Ribble Valley Borough Council  
Housing & Development Control

Application no: **3/2021/0256**

Address: **7 Tennyson Avenue Read BB12 7RN**

Proposal: **Proposed single detached garage, front extension adjacent to porch, removal of three windows from kitchen and one window from utility as a revision to original plan approval ref 3/2020/0304**

PROPOSED DETACHED GARAGE

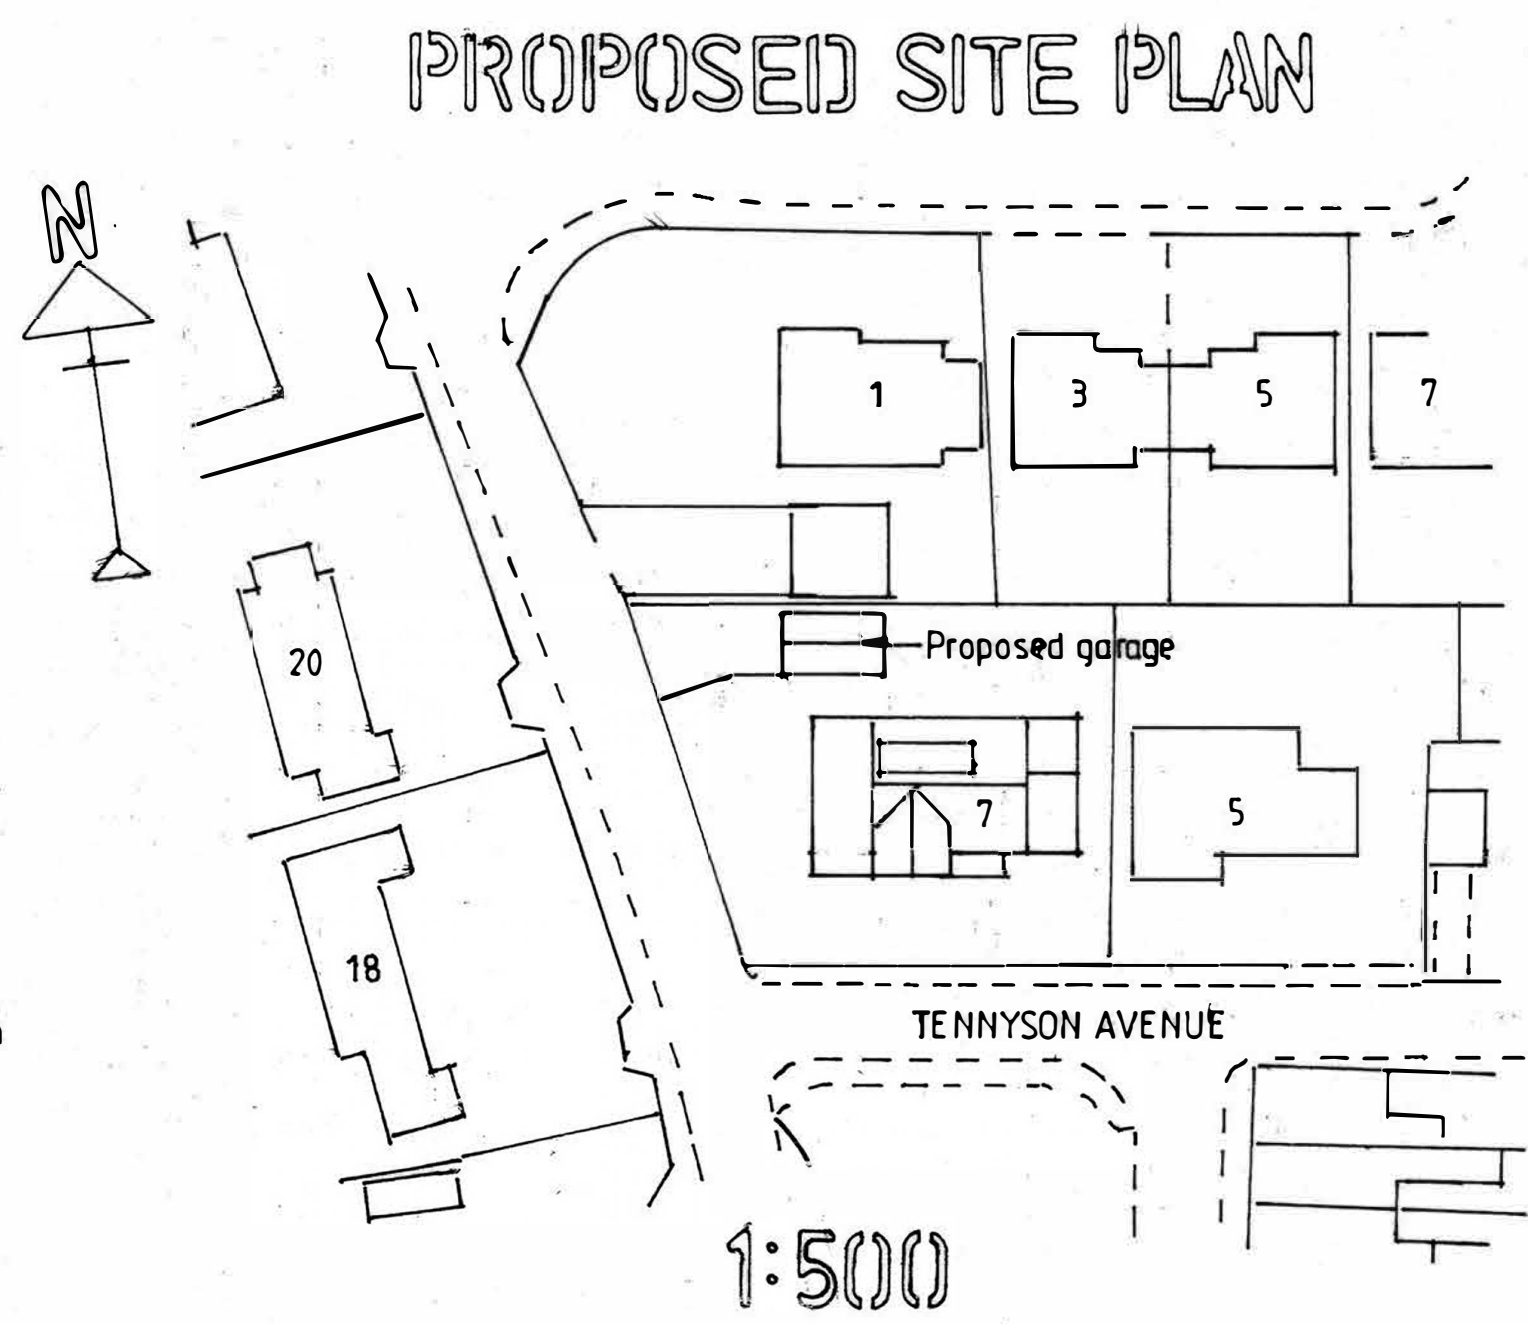
Access to the proposed garage will need to be carried out by Lancashire County Council under section 184 of the Highways Act 1980.

The use of permeable paving for the proposed hardstanding is something in which the local highway authority supports however without an exploratory ground investigation, the substratum may not be free draining and thus not support the concept of permeable hardstanding. The local highway authority requests that the applicant provides measures to intercept any surface water run-off entering the adopted highway from the application site.

1. The surface water from the approved driveway/hardstanding should be collected within the site and drained to a suitable internal outfall. Prior to commencement of the development details of the drainage strategy shall be submitted to and approved in writing by the Local Planning Authority. The scheme shall be implemented in accordance with the approved details.
